**Comhairle Chontae Uíbh Fhailí**  
**Offaly County Council**

**Views of the Elected Members on Strategic Infrastructure Development in  
accordance with Section 37E(6))37E(4) of the Planning and Development Act  
2000 (as amended)**

**Ballinla Wind Farm**

**An Coimisiún Pleanála Case reference: PAX19.323579**

Figure 6: Turbine T1 to T5 buffer zones

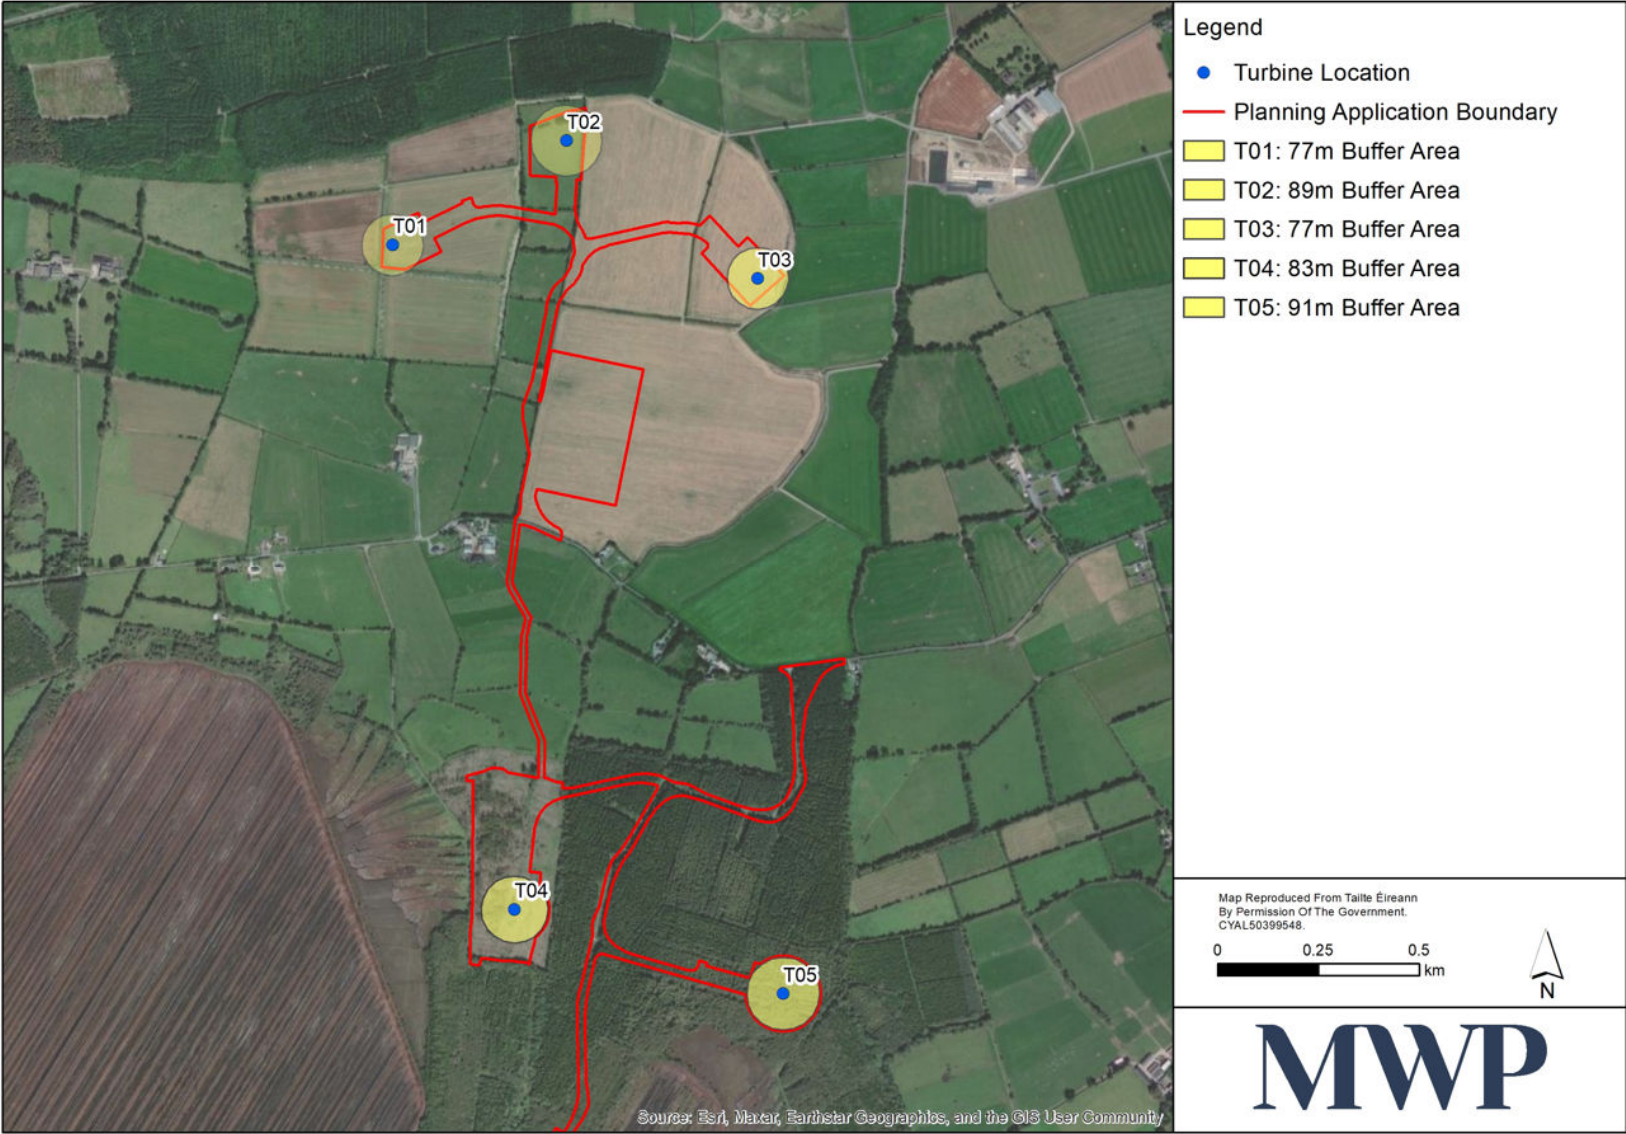
Concerns raised about the location of the proposed wind farm development, close to residences and a built-up area (in particular T1 – T4) and the distance between the proposed turbines and nearby homes. It was stated that there is a need for a setback of 750m (or greater) from residential units, in line with best practice and so as to protect residential amenities.

Figure 5-2: Flood Zone Map

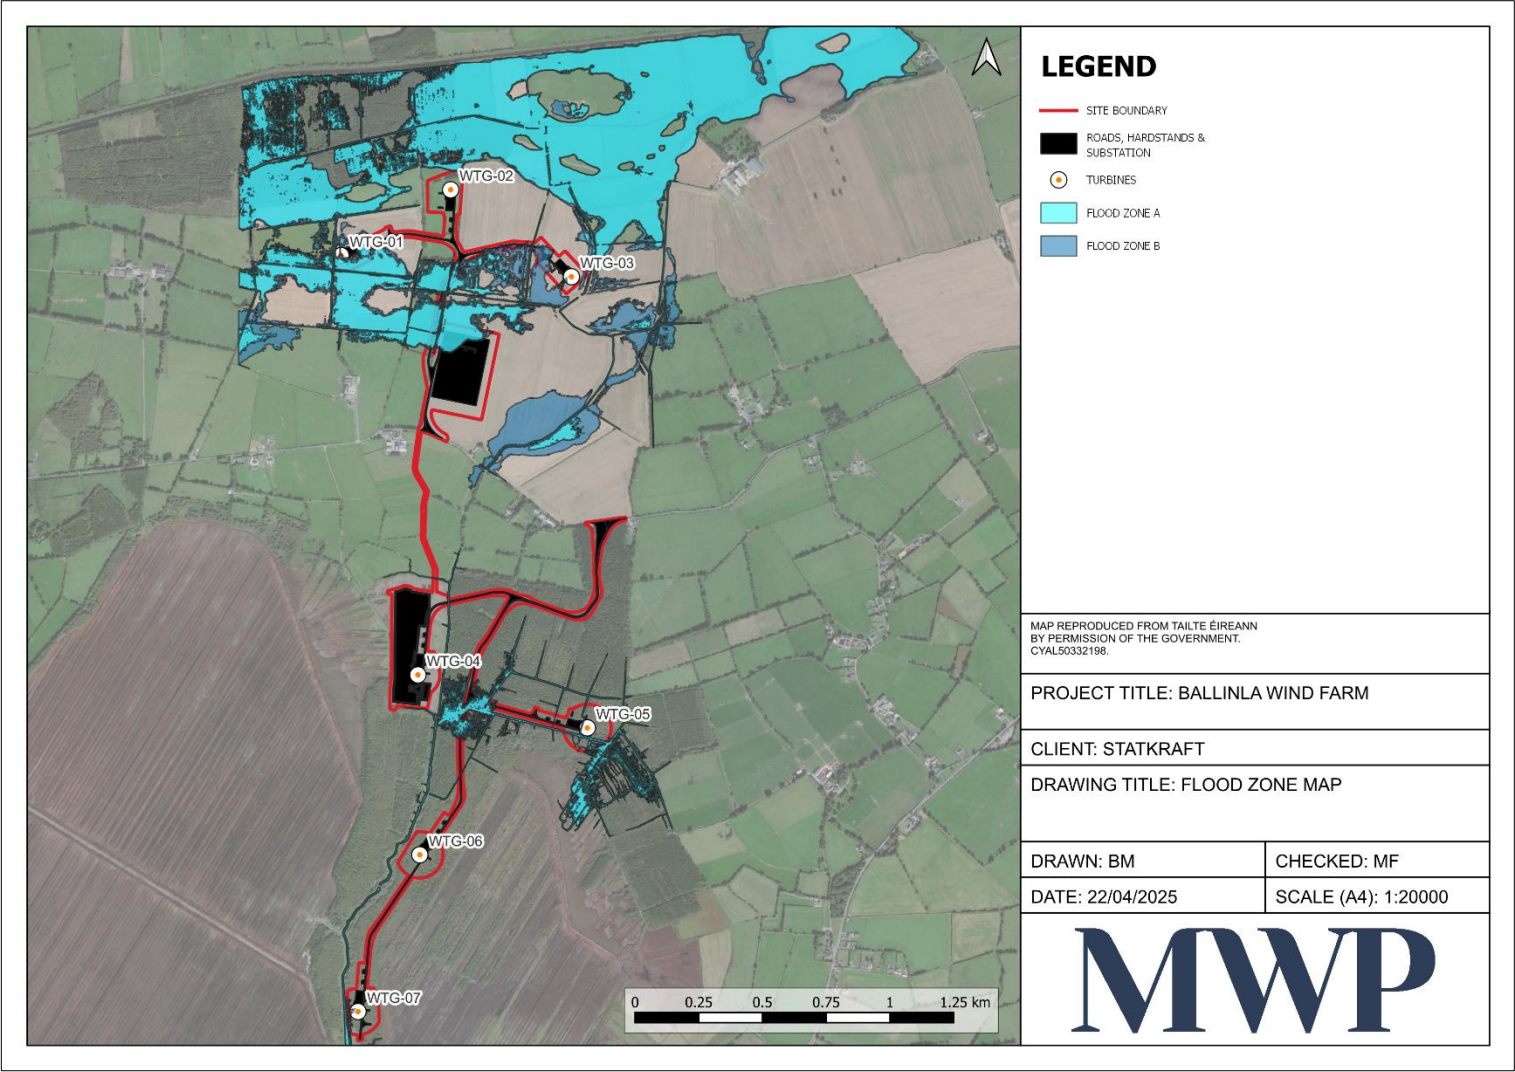
Concerns raised that Turbines 1, 2, and 3 are located within a flood risk area and that any future flooding could result in financial implications for Offaly County Council.

Figure 2-1: Proposed Development Haul Routes

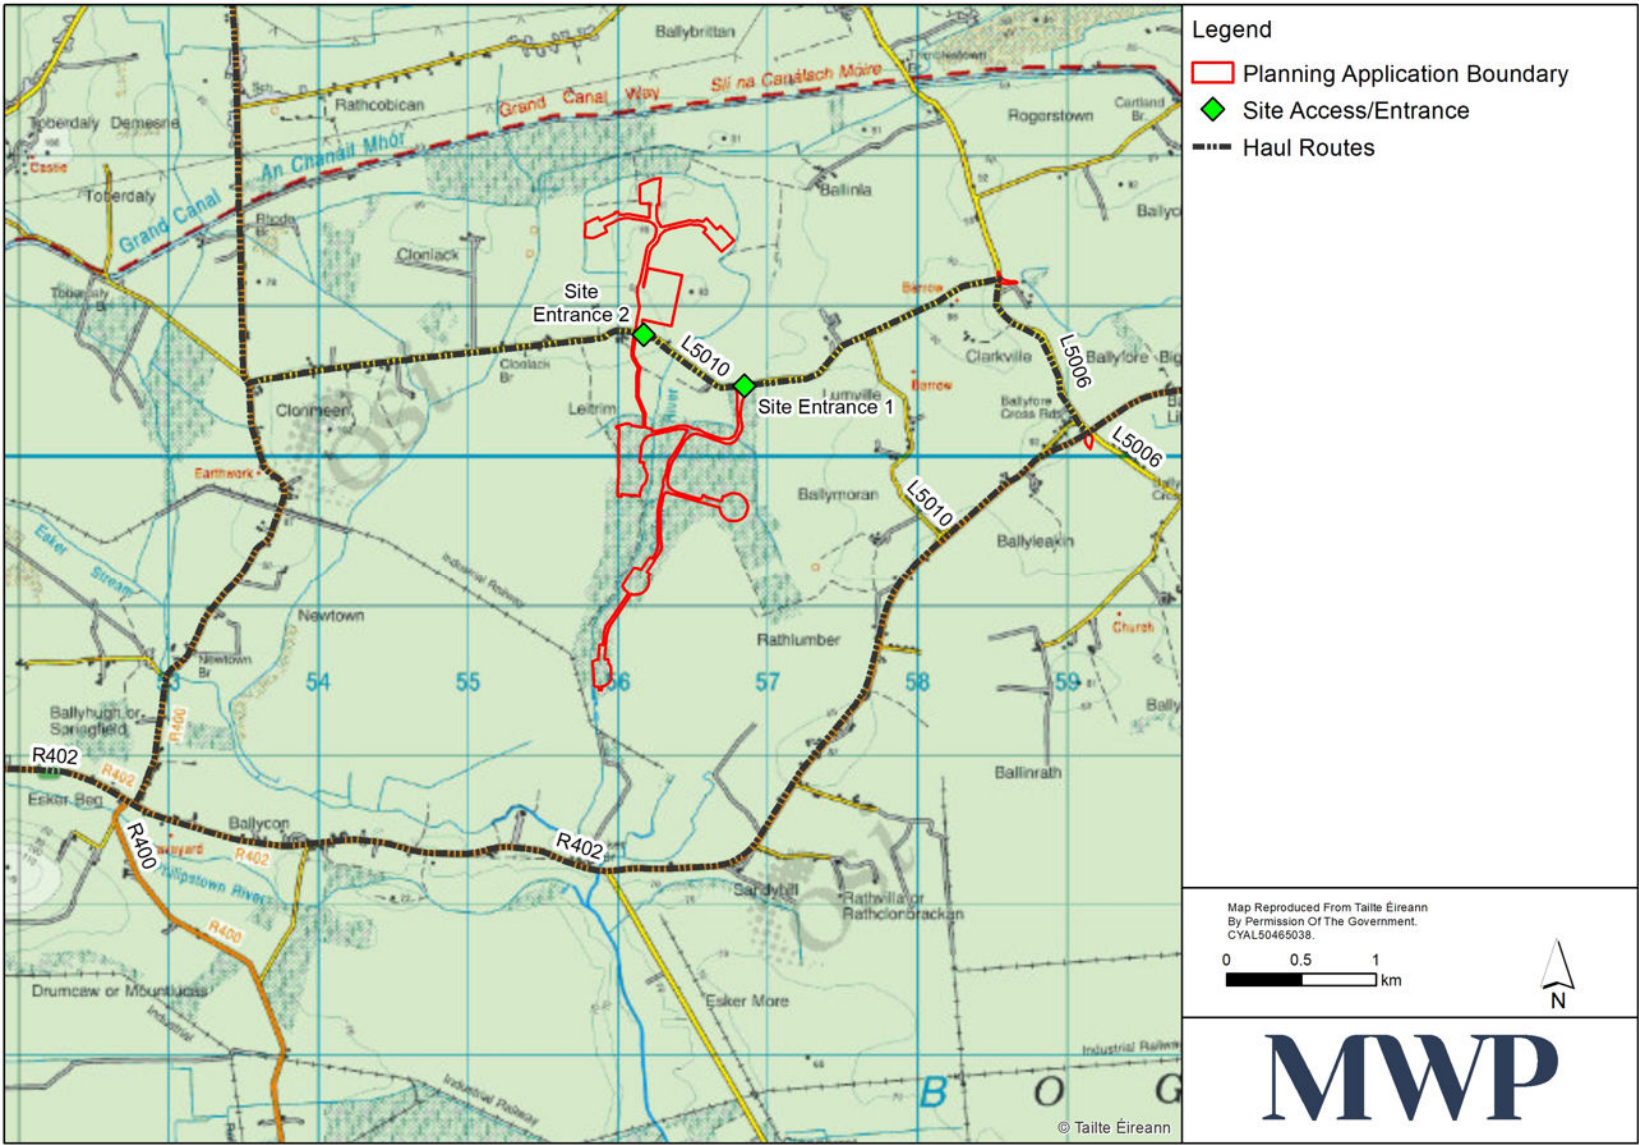
Concerns raised on the significant impact the development would have on local roads and the potential disruption to residents in the area.
